Householder Proforma

Application Ref: 2022/0217
Address: 10 Francus Royd, Carlton, Barnsley, S71 3FF
Property Description: The detached buff brick dwelling is located in a modern housing development and benefits from a two-storey extension and single storey rearwards projection which forms part of the original dwelling. The dwelling is situated to the east of open green space and is screened by shrubbery which is located along the eastern boundaries of the green space.

Proposed Extension: Erection of first floor extension to rear of dwelling.

Title: PROPOSED PLANS AND ELEVATIONS

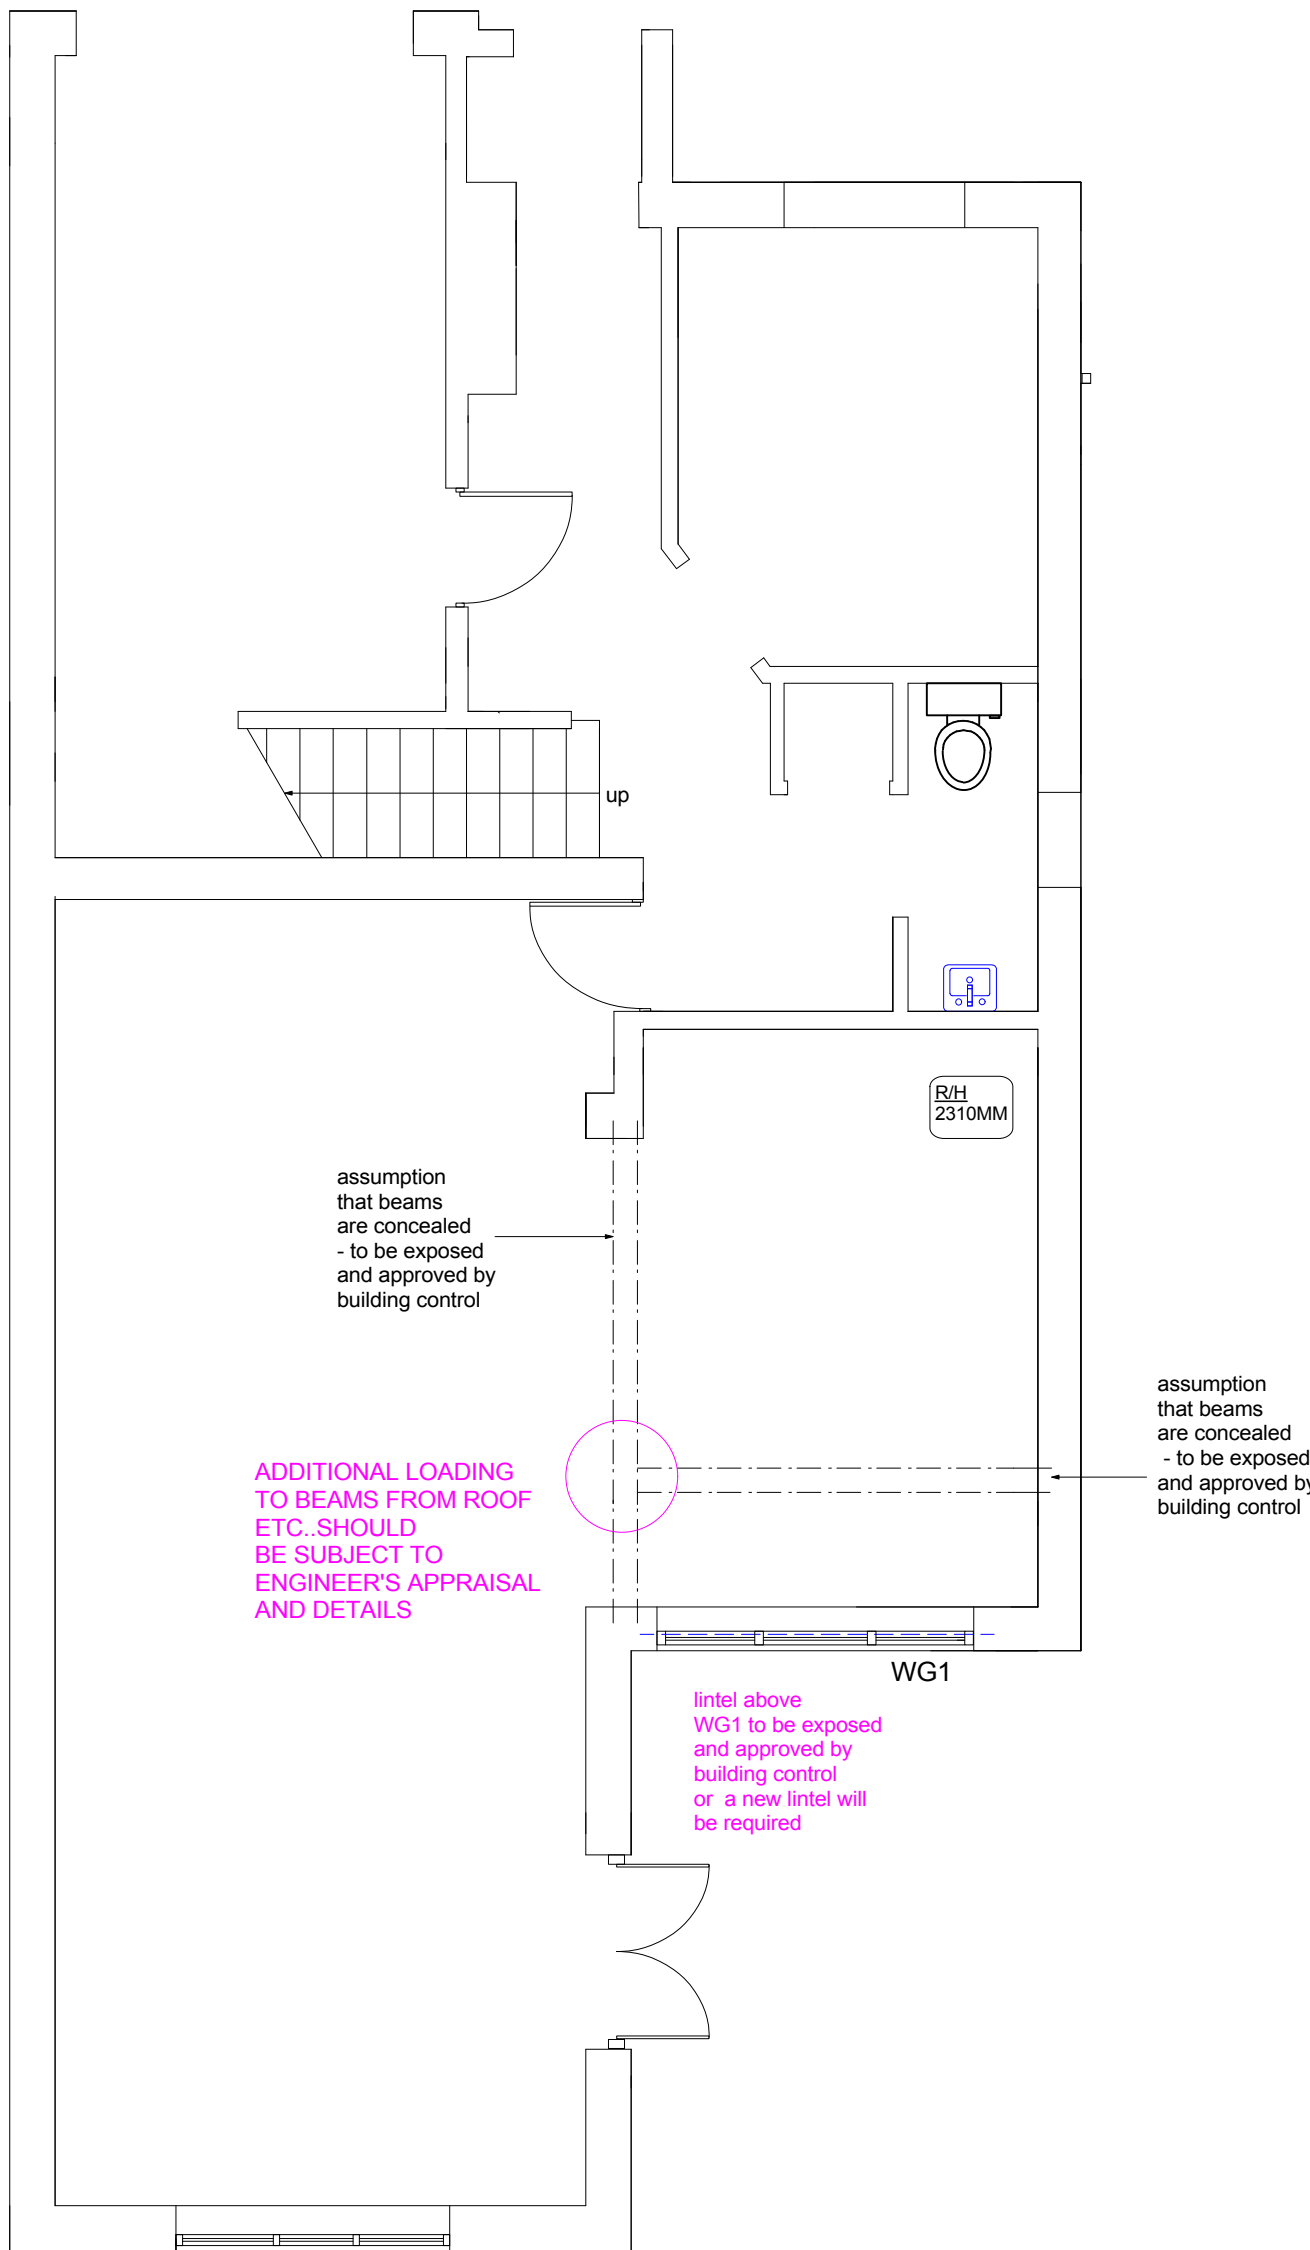
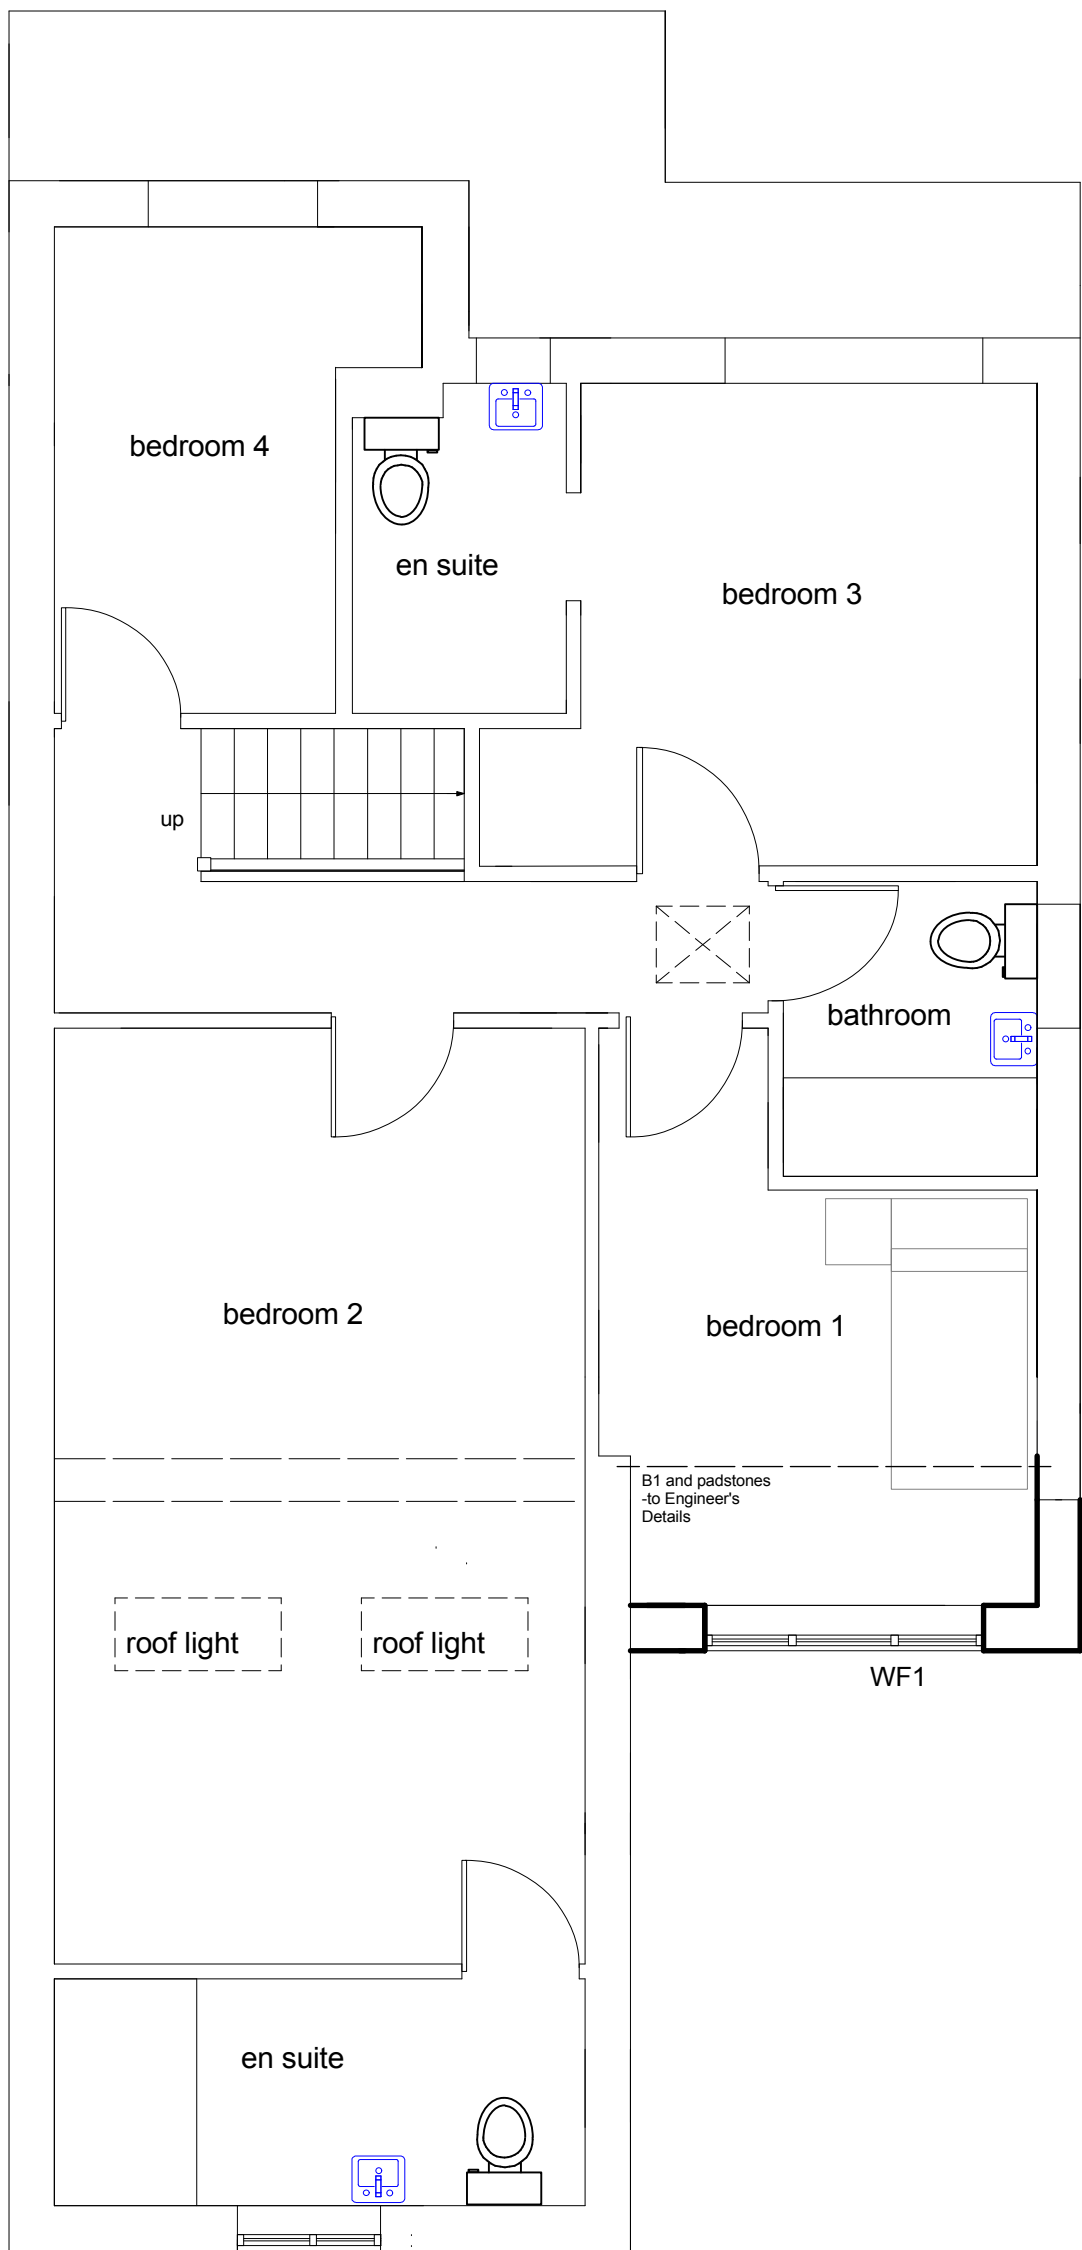
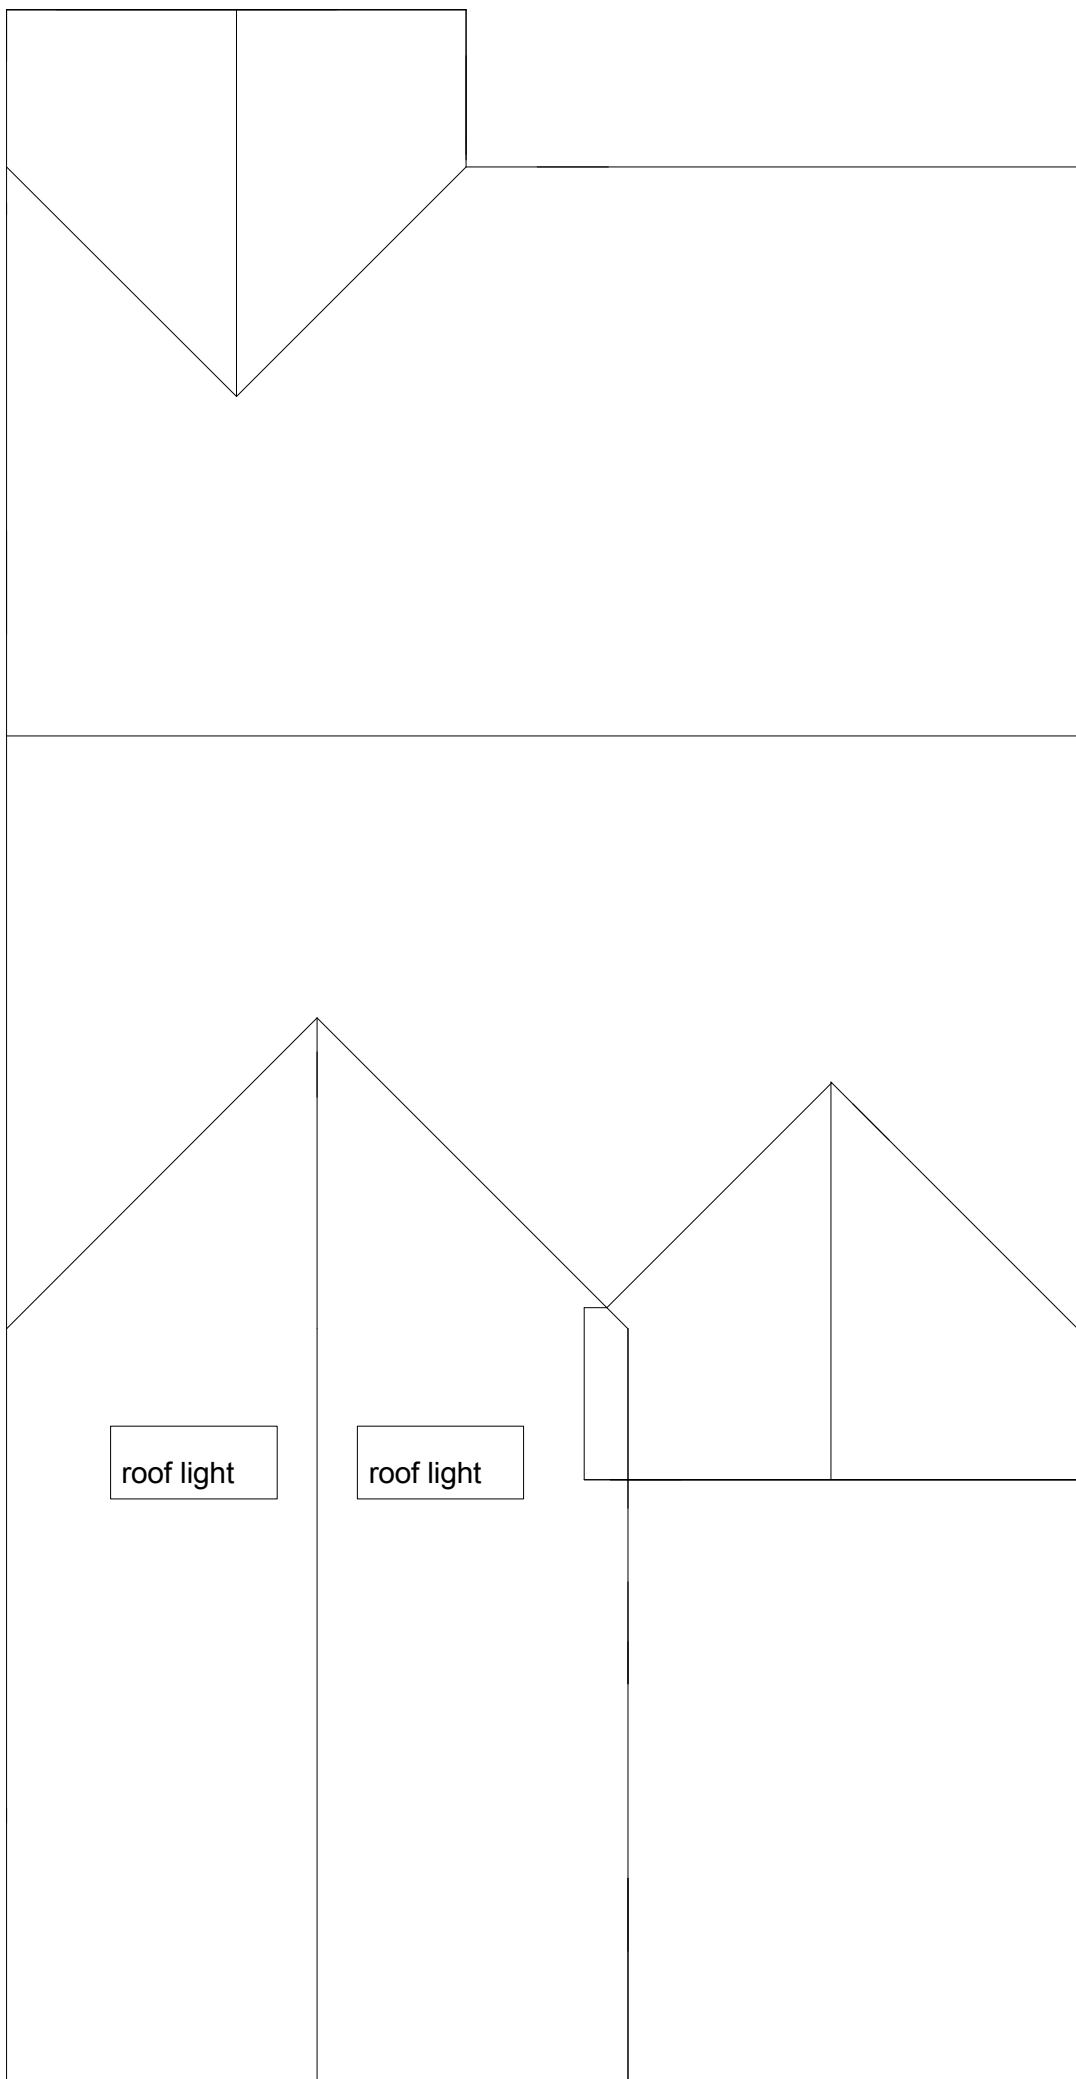
The applicant seeks permission for the erection of a 1.3m first floor extension above an existing single storey projection on the rear elevation of the dwelling. The proposed extension is modest in nature and would not lead to an increase in overshadowing or loss of outlook to an unreasonable level. Whilst the proposed extension would project closer to the rear boundary, it would not project closer than the existing two

storey rear projection, therefore not increasing levels of overlooking to an unreasonable level. It is proposed to be constructed from materials which match the original dwelling along with a roof style and pitch which harmonises and remains subordinate to the main property.

Recommendation: Approve with conditions
